August 9, 2022

**Re: Technical Review #2 Comments – PA22-019
Groundhog PRD, 5110 83 Avenue NE, Marysville, WA**

Re: PA22-019 - Groundhog PRD – Technical Review 2

**COVER SHEET**  
GROUNDHOG PLANNED RESIDENTIAL DEVELOPMENT

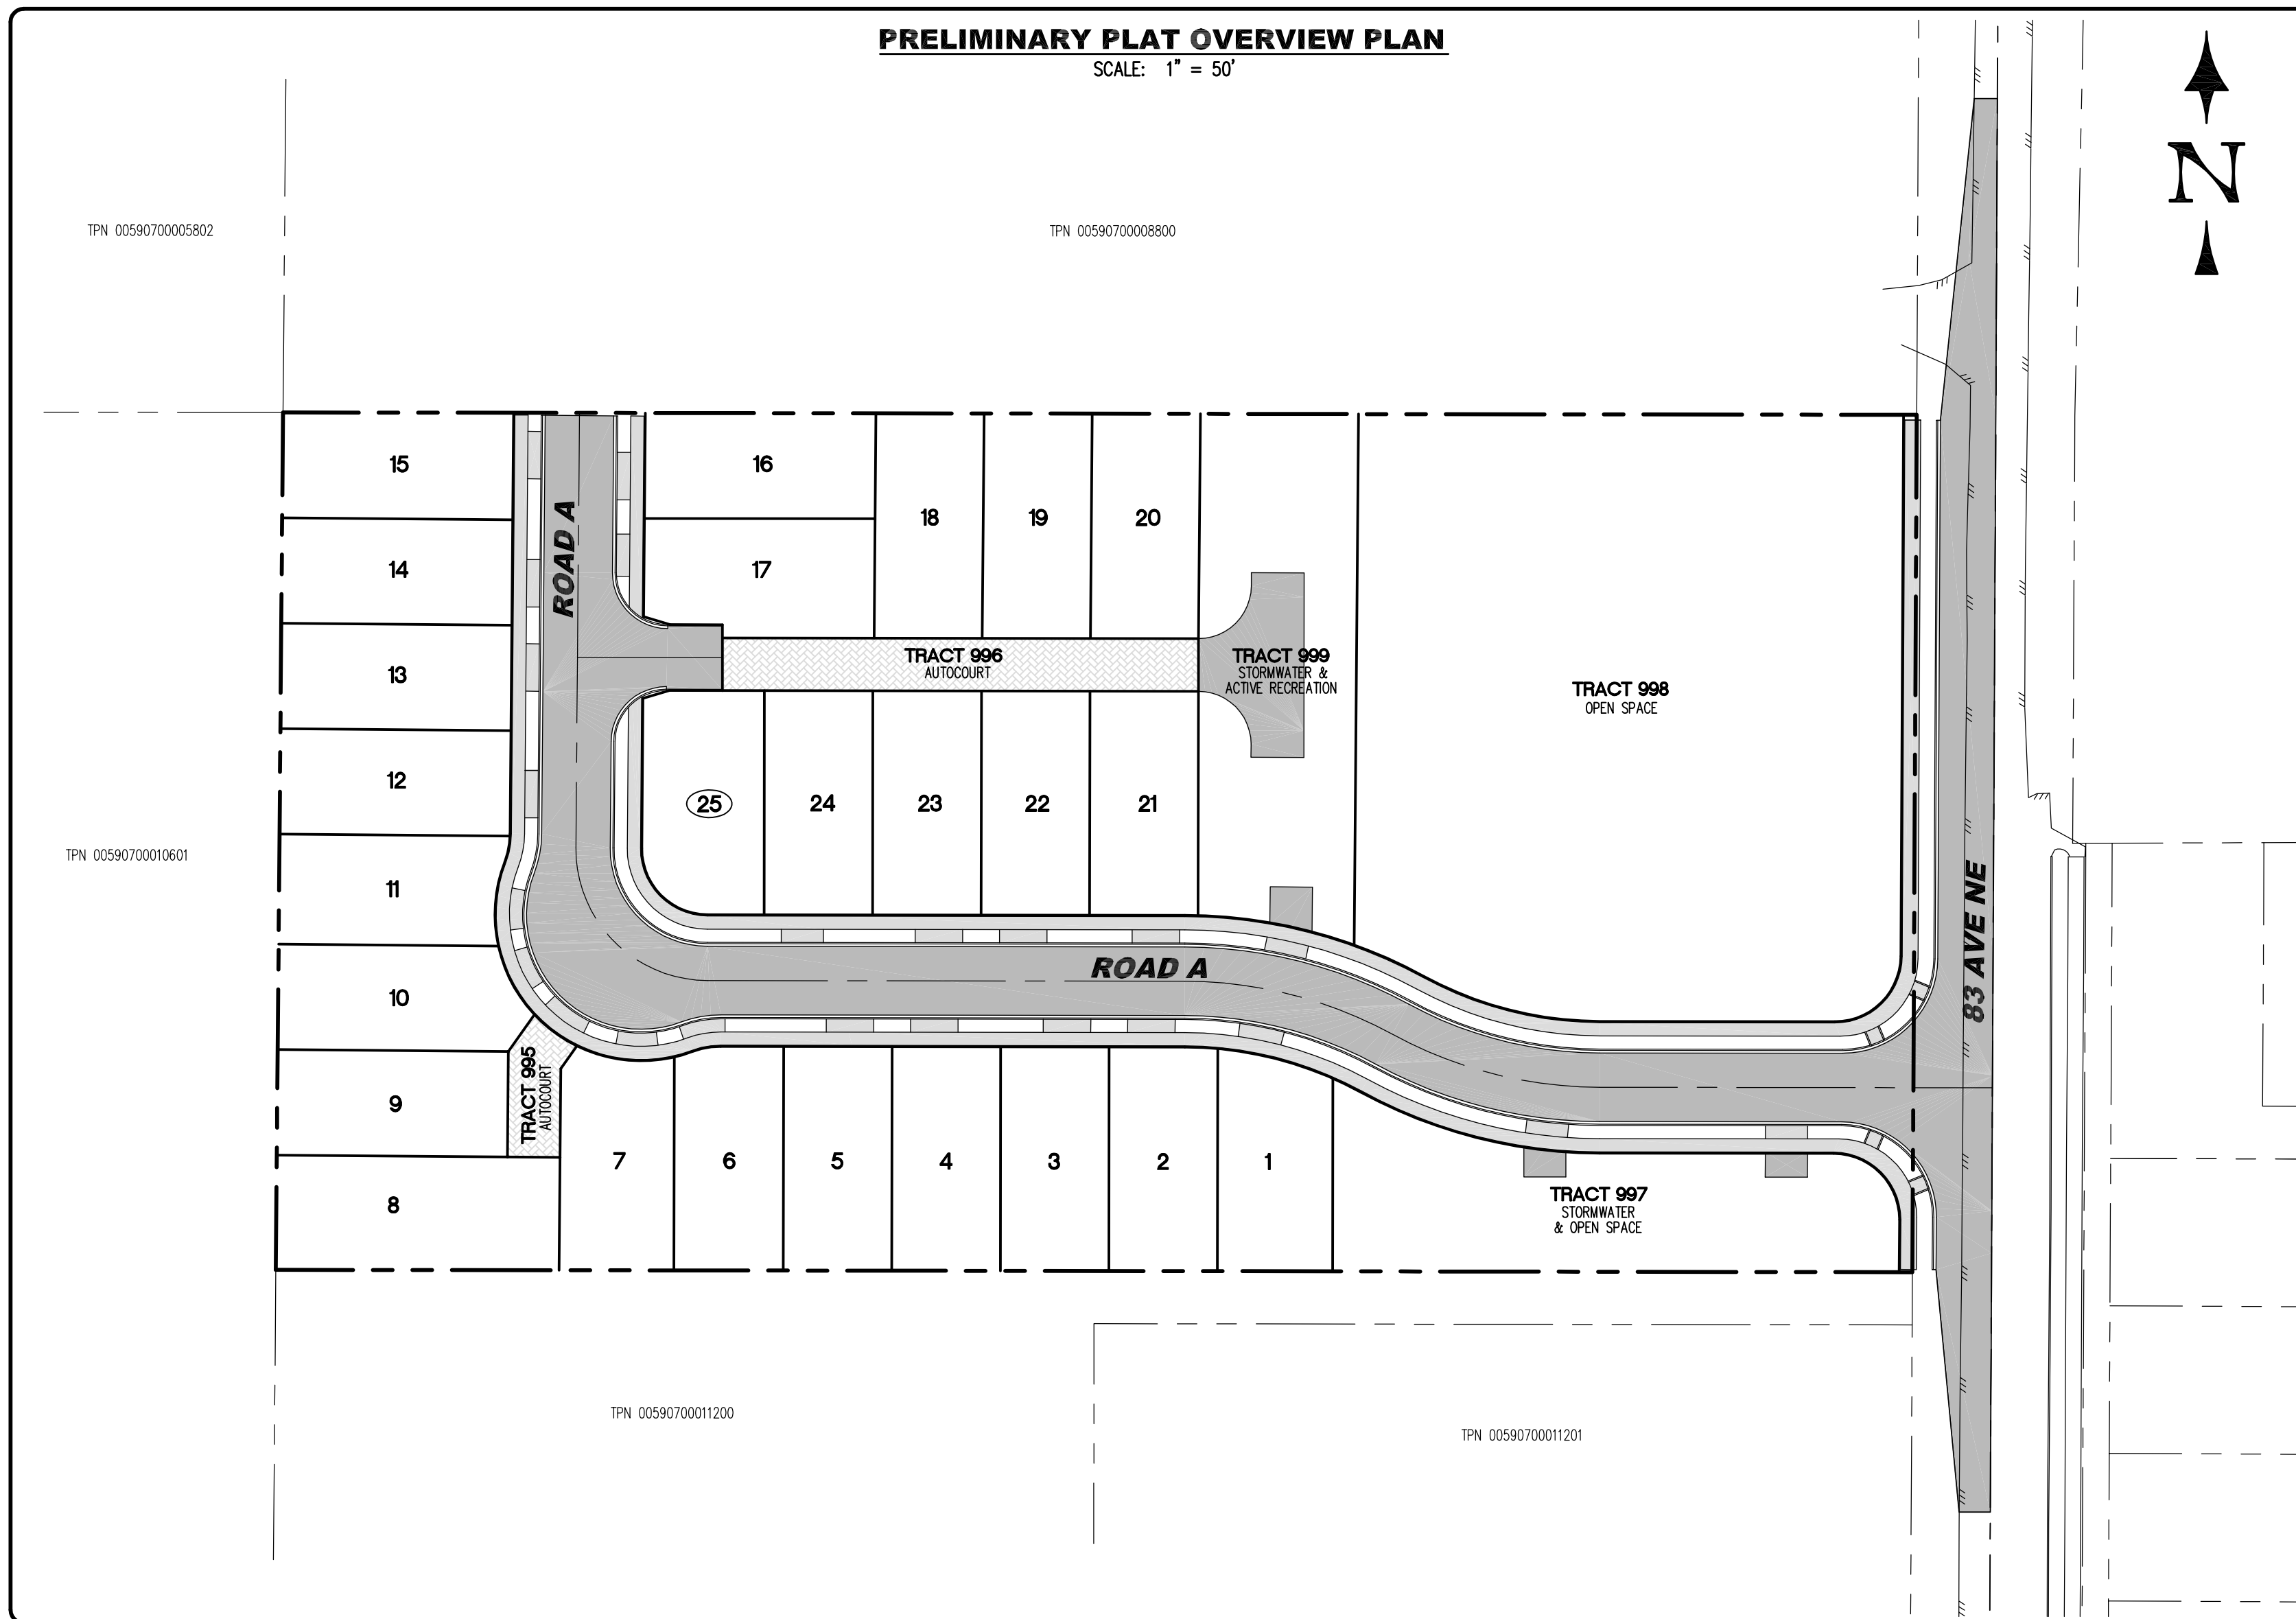
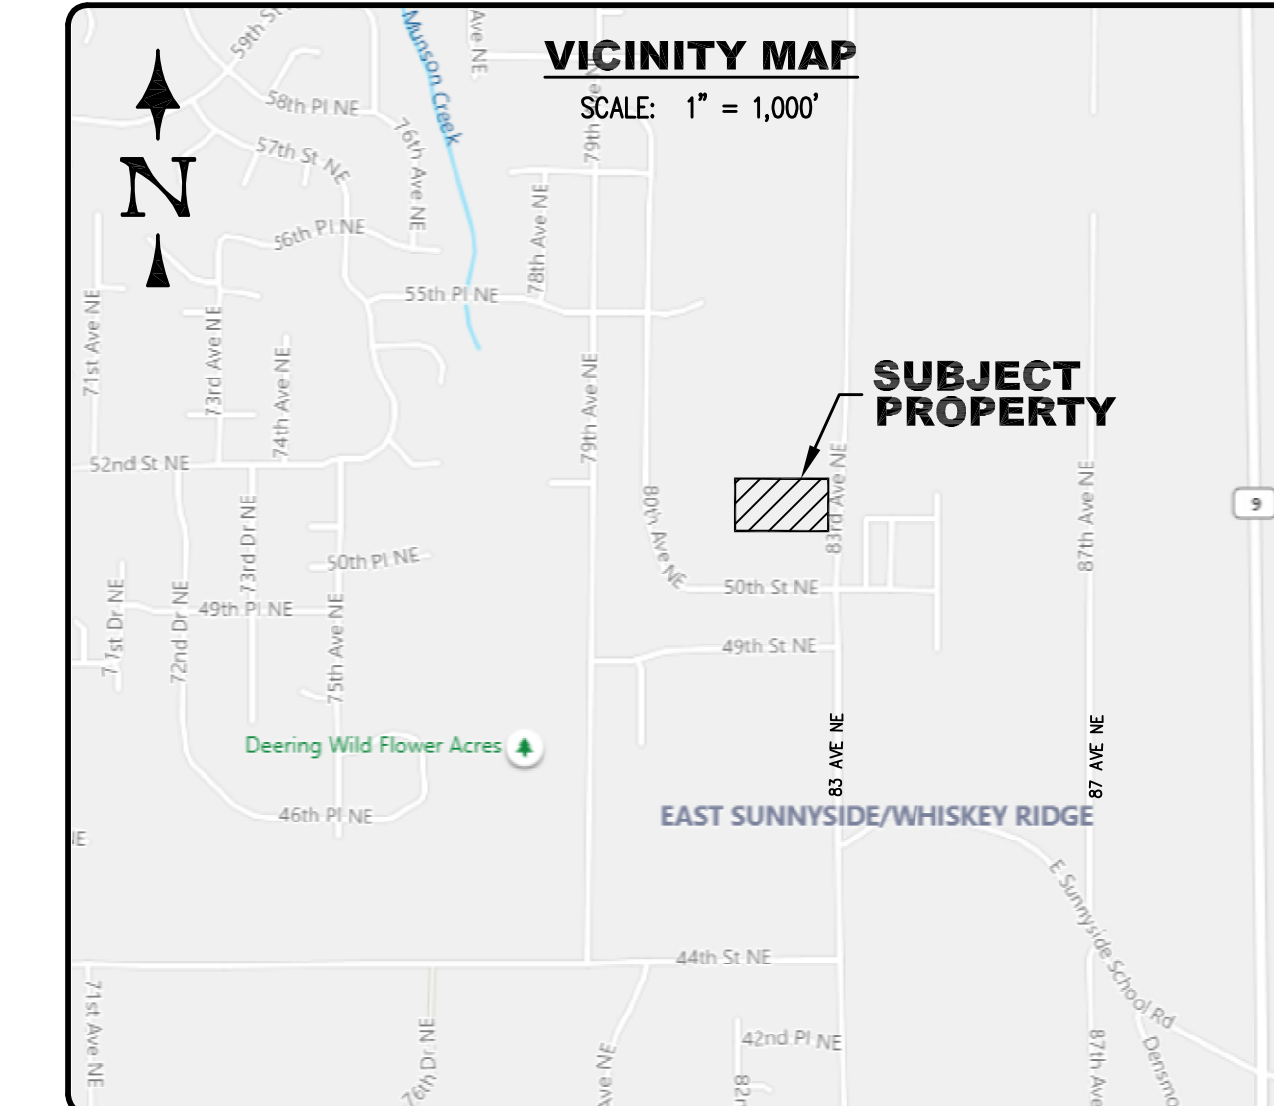
1. Pursuant to MMC 22E.010.120(3)(c) for wetland mitigation ratios, Category III wetlands require mitigation of ratios of 2:1 for enhancement areas along with 1:1 for re-establishment or creation of buffers. Provide an addendum to the Conceptual Mitigation Plan that clarifies that these required ratios would be satisfied through onsite compensatory mitigation and off-site contribution to the SBMB.
 - See attached Technical Memorandum prepared by Soundview Consultants dated Aug 9, 2022.
2. (Email Comment) – The cover sheet of the revised civil plans has the pre-app number. Please revise to include the PA number.
 - The File Number PA22-019 is now shown on the Civil cover sheet title as noted (see attached).
